SPR EA1N and EA2 PROJECTS

DEADLINE 9 – COMMENTS ON DEADLINE 8 FLOOD RISK SUBMISSIONS

Interested Party: SASES **PINS Refs:** 20024106 & 20024110

Flood Risk related responses to Deadline 8 submissions on Scottish Power Renewables proposed EA1N and EA2 onshore works near Friston

Figure 1 Potential Sensitive Receptors and Areas Subject to Additional Construction Phase Controls

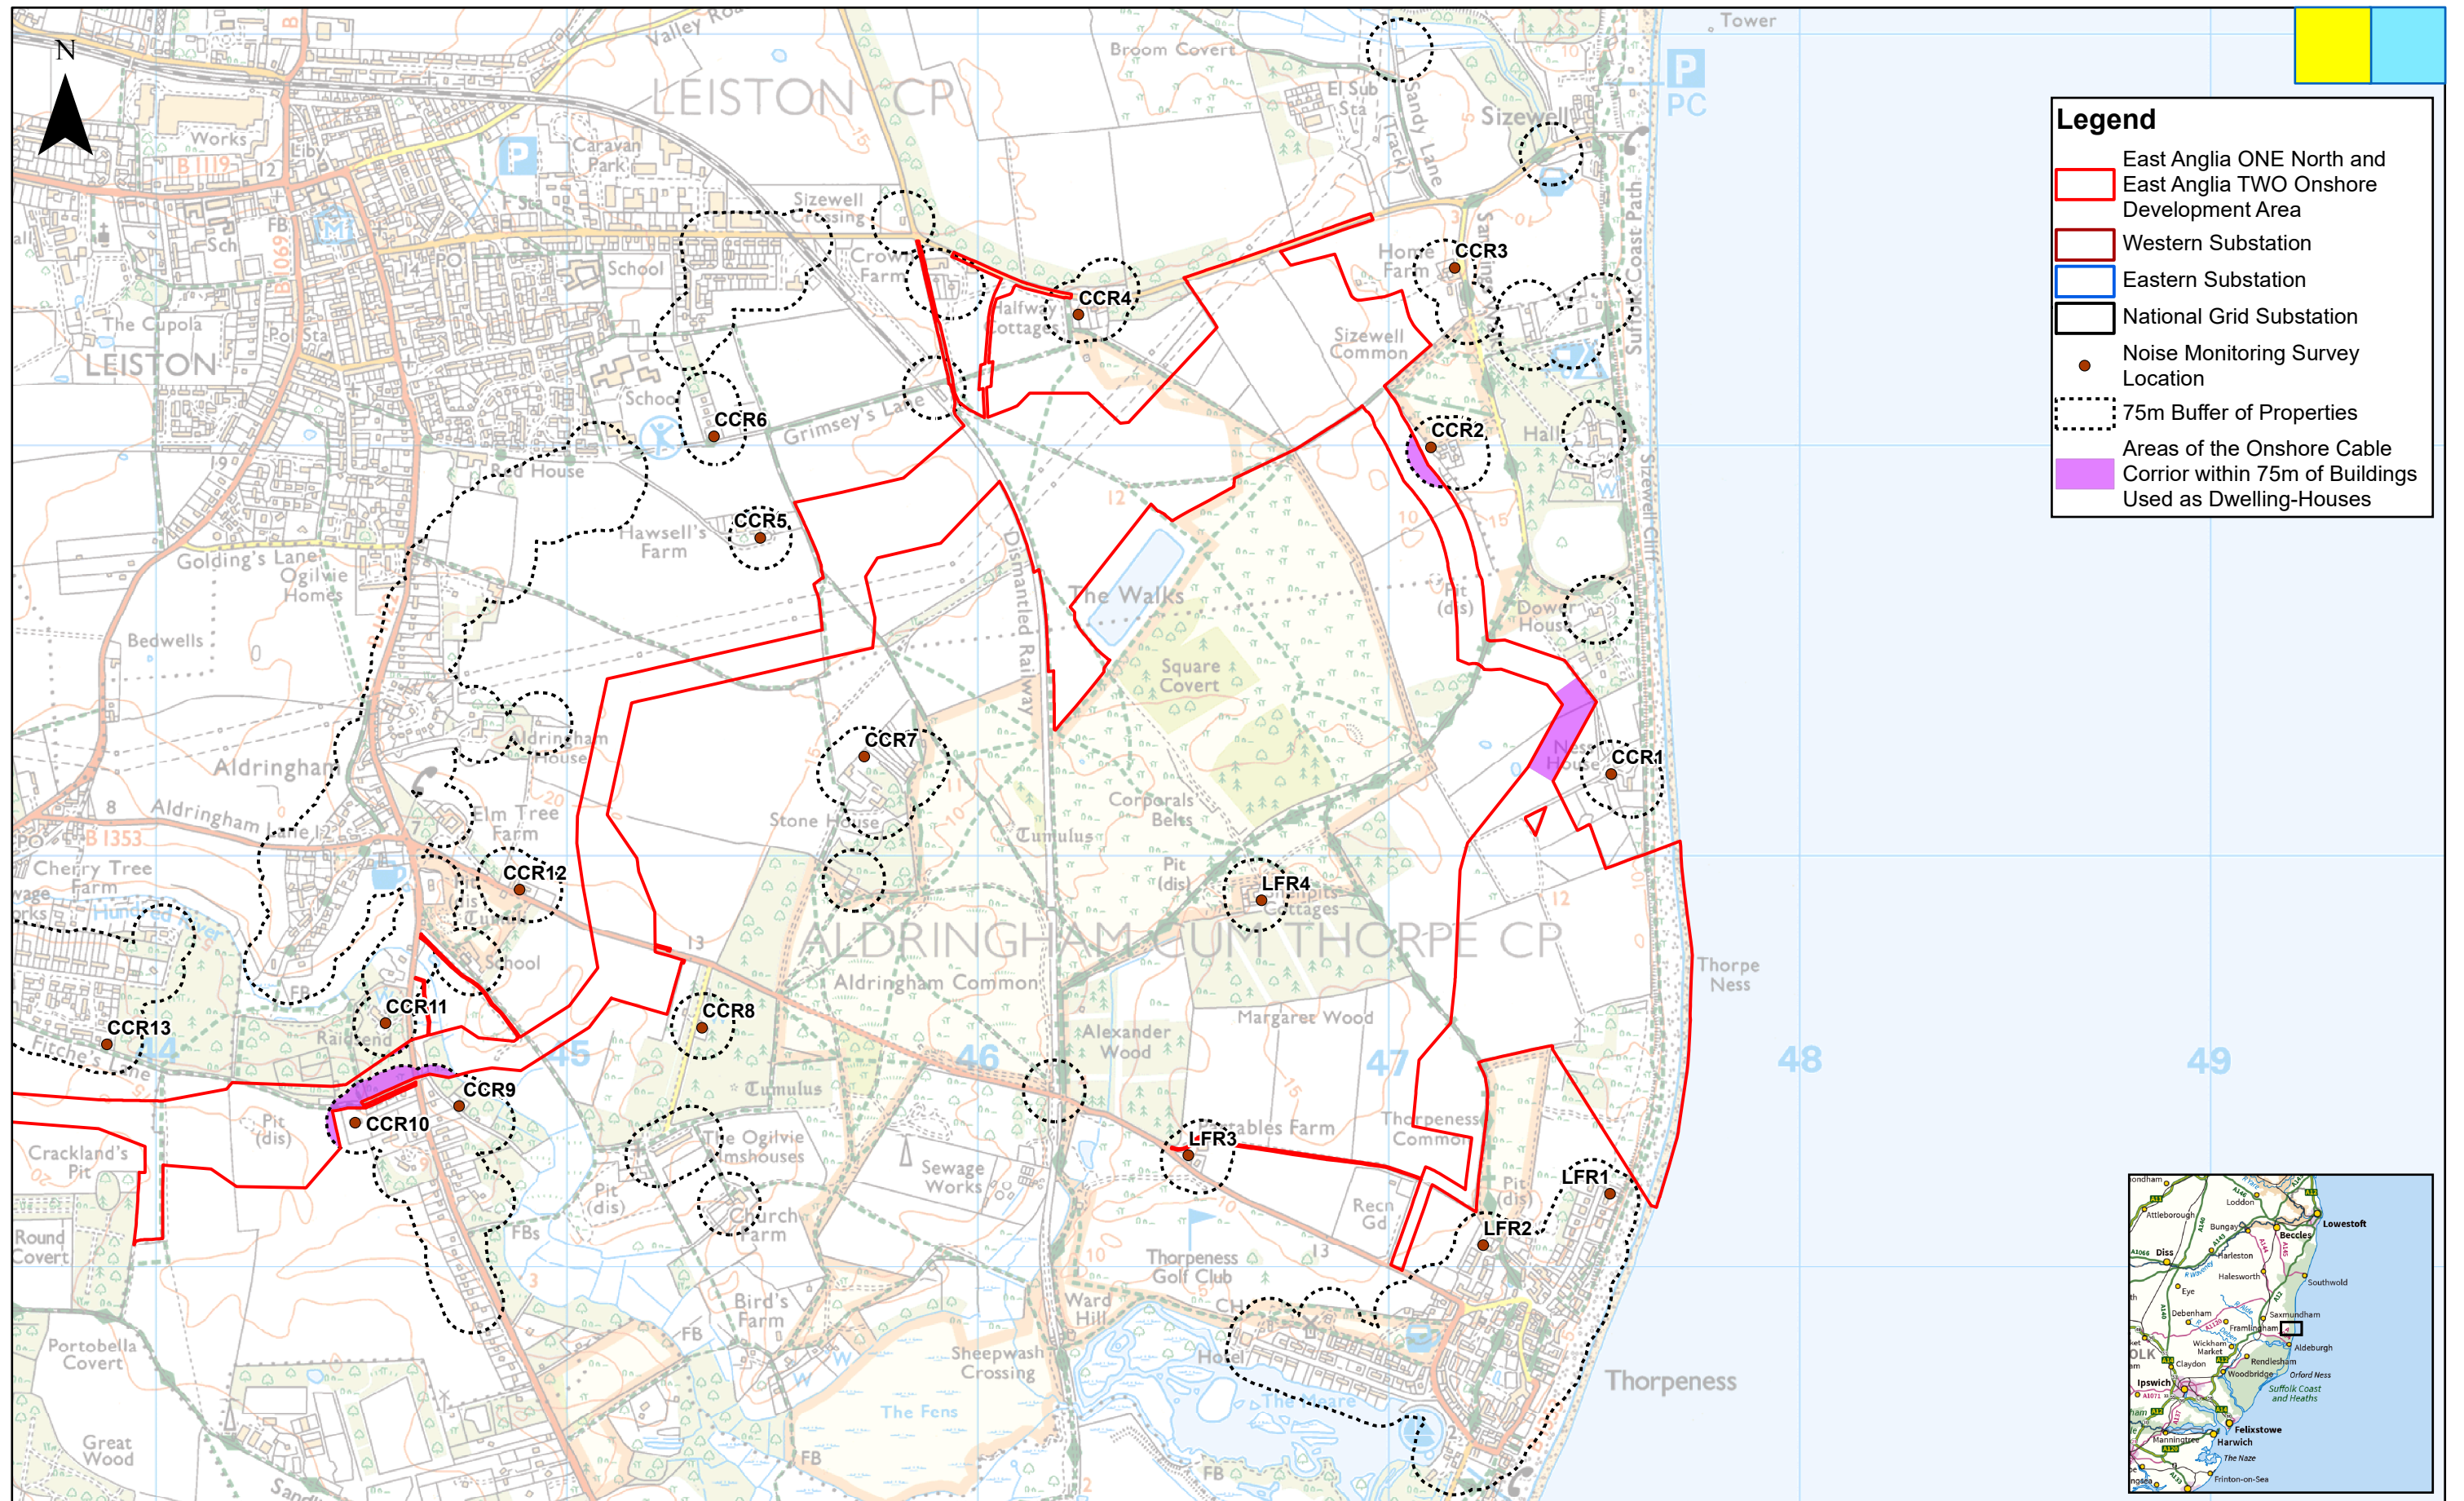
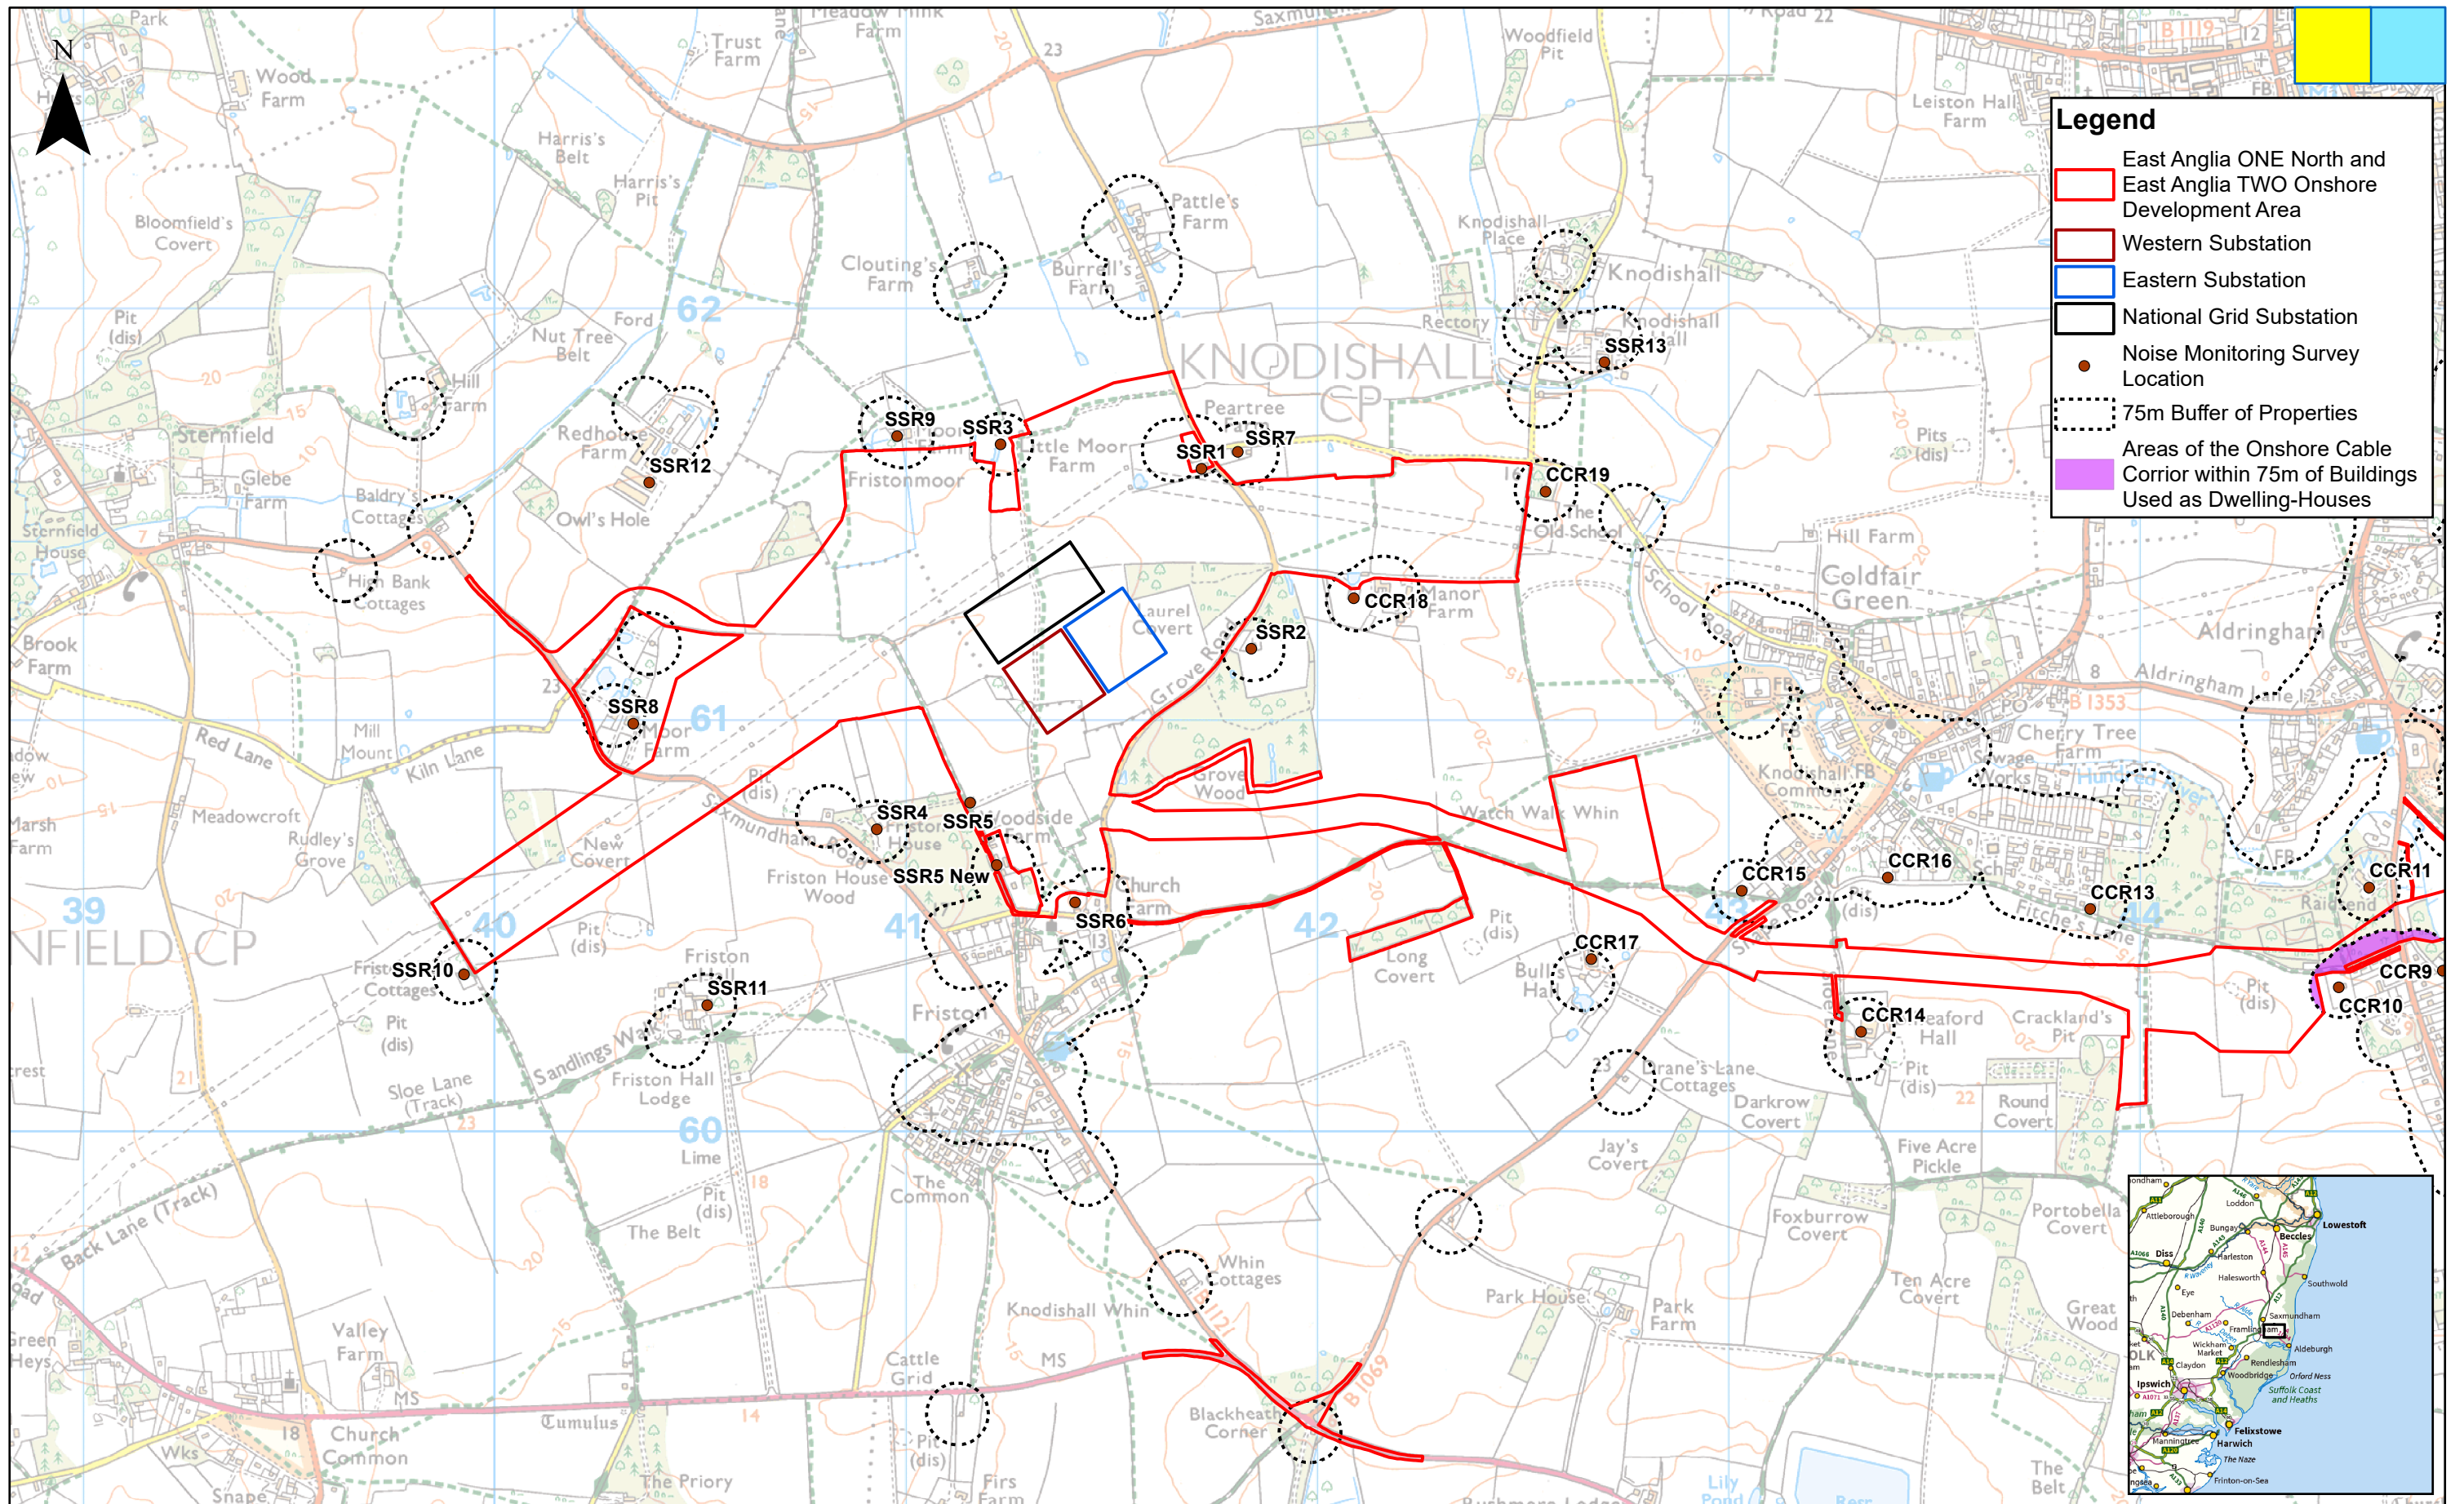
The Applicant has submitted an updated CoCP. The only substantive update within it states that detailed evaluation of each onshore section will be undertaken prior to construction to inform design of the construction phase surface water management scheme.

Whilst the Applicant is now recognising the construction phase does have phase specific flood risk impacts (eg area and turbidity), the above statement does not provide any evidence the construction phase flood risk impacts have been properly assessed (given our on-going concerns about the inadequacy of the baseline flood risk assessment) nor whether adequate mitigation is actually viable.

The management of flood risk within the CoCP is almost entirely absent. This is completely unacceptable.
